City of Albuquerque Stormwater Construction Site Inspection Report

General Information					
ESC File No.	M15E054	Project Name:	Veterans Integration Center		
NPDES Id. No.	NMR1005M1	Location:	2701 Mulberry St SE		
12/2/2025	Owner	Contractor			
Operator	NM Veteran Integration Centers		Hart Construction		
Contact name & title	Jerry Becker				
e-mail	jerry@steomaticnm.com				
Contact Phone #	505-991-4708				
COA Inspector	Chancellor English	Start/End Time:	12pm		
Construction Phase:	south addition interiors				
Type of Inspection:	Regular	Storm Event	Post Storm Event >0.25"	311/Complaint	Follow Up
Weather at time of inspection?	Clear		Temperature: ~	50	
Estimated date of last storm 0.25" or greater	11/20/2025

ESC-1

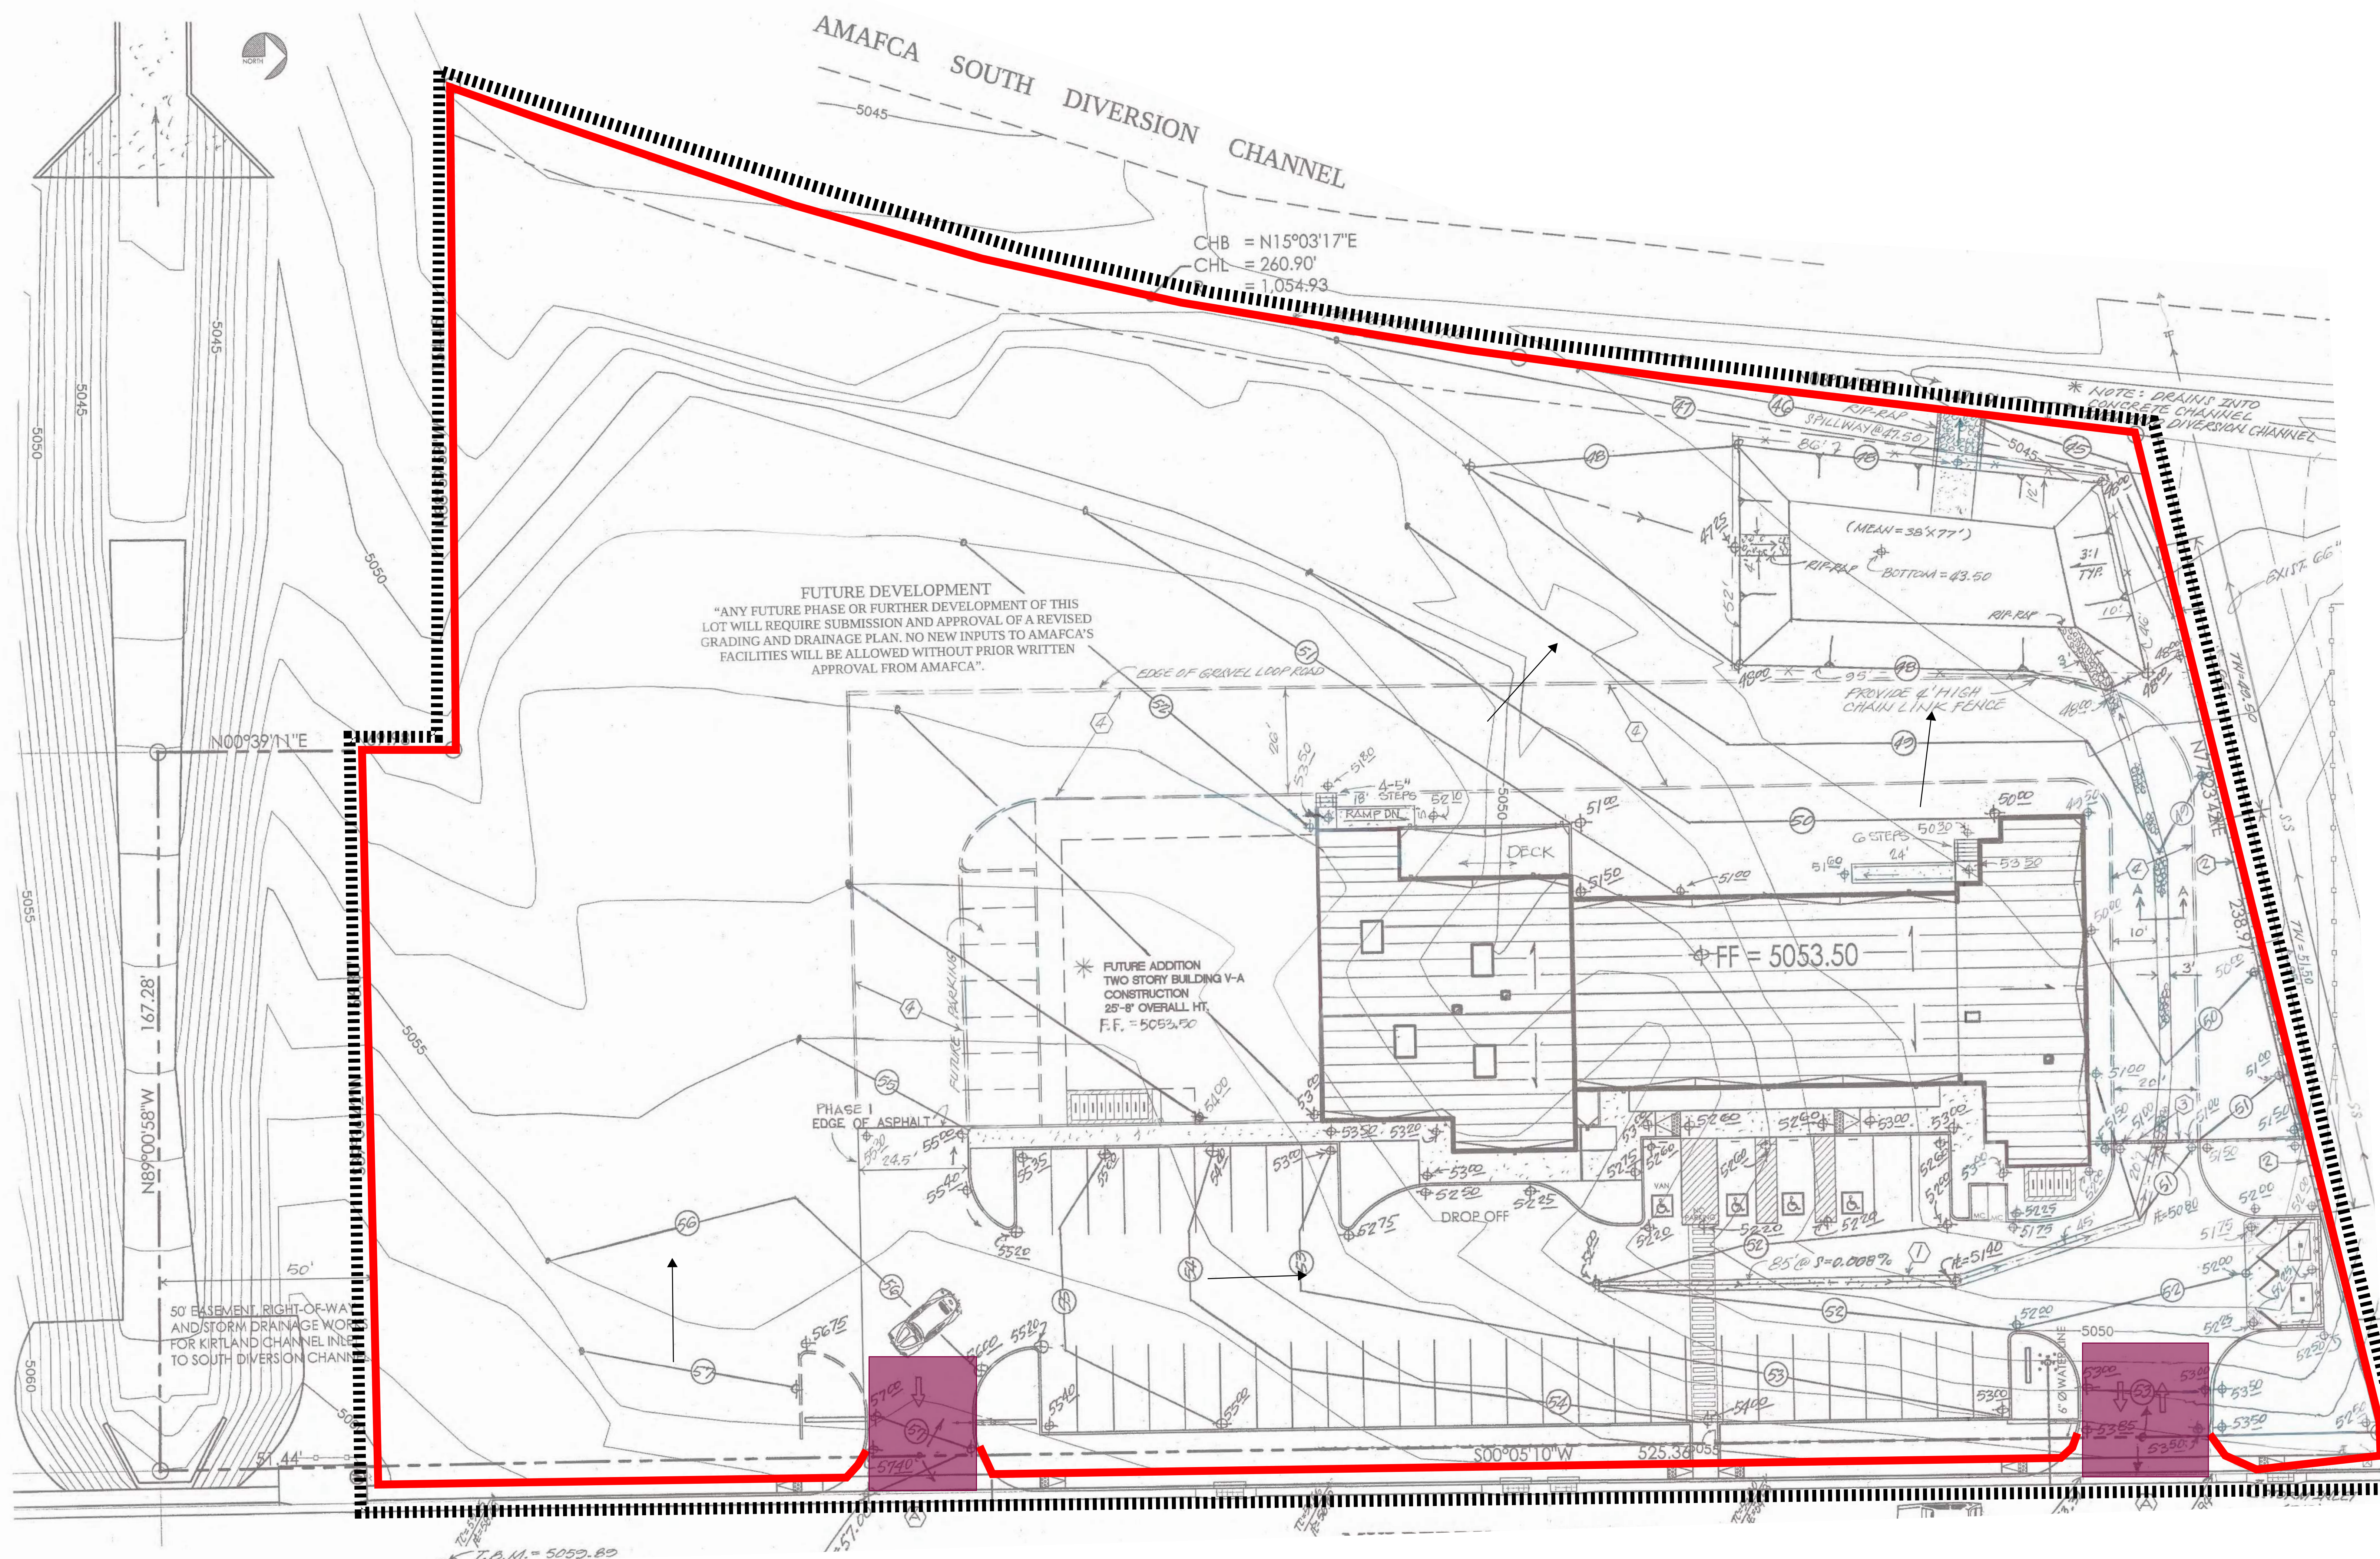
Item Number	Deficiency/ Corrective Action				
1	<p>SWPPP - The following information is missing from the SWPPP, which needs modification in violation of several CGP Parts. The operators need to be updated to identify the new operator, Hart Construction (CGP Part 7.2.1). The Stormwater Team needs to be updated to identify the personnel (by name and position) responsible for CGP compliance, along with their individual responsibilities (CGP Part 7.2.2). The SWPPP needs to be certified by each operator's signatory (CGP Part 7.2.10). The Notices of Intent (NOIs) for each operator need to be included in the SWPPP (CGP Part 7.2.11). The SWPPP, including the SWPPP Map, needs to be amended to reflect the current conditions on the ground (CGP Part 7.4.1). Copies of all self-inspection reports need to be available for an on-site inspection (CGP Part 4.7.3). Required mitigation: Include a list of all other operators who will be engaged in construction activities at the site, and the areas of the site over which each operator has control per CGP Part 7.2.1. Identify the personnel (by name and position) that you have made part of the stormwater team pursuant to CGP Part 6.1, as well as their responsibilities per CGP Part 7.2.2. Your signatory must sign and date your SWPPP in accordance with CGP Appendix G, Part G.11. You must include a copy of your NOI submitted to the EPA along with correspondence exchanged between you and the EPA related to coverage under this permit per CGP Part 7.2.11.a. You must modify your SWPPP, including the site map(s), within seven days whenever new operators become active in construction activities on your site, or you make changes to your construction plans, stormwater controls, or other activities at your site that are no longer accurately reflected in your SWPPP per CGP Part 7.4.1.a. You must keep a copy of all inspection reports at the site or at an easily accessible location so that they can be made immediately available at the time of an on-site inspection per CGP Part 4.7.3.</p>
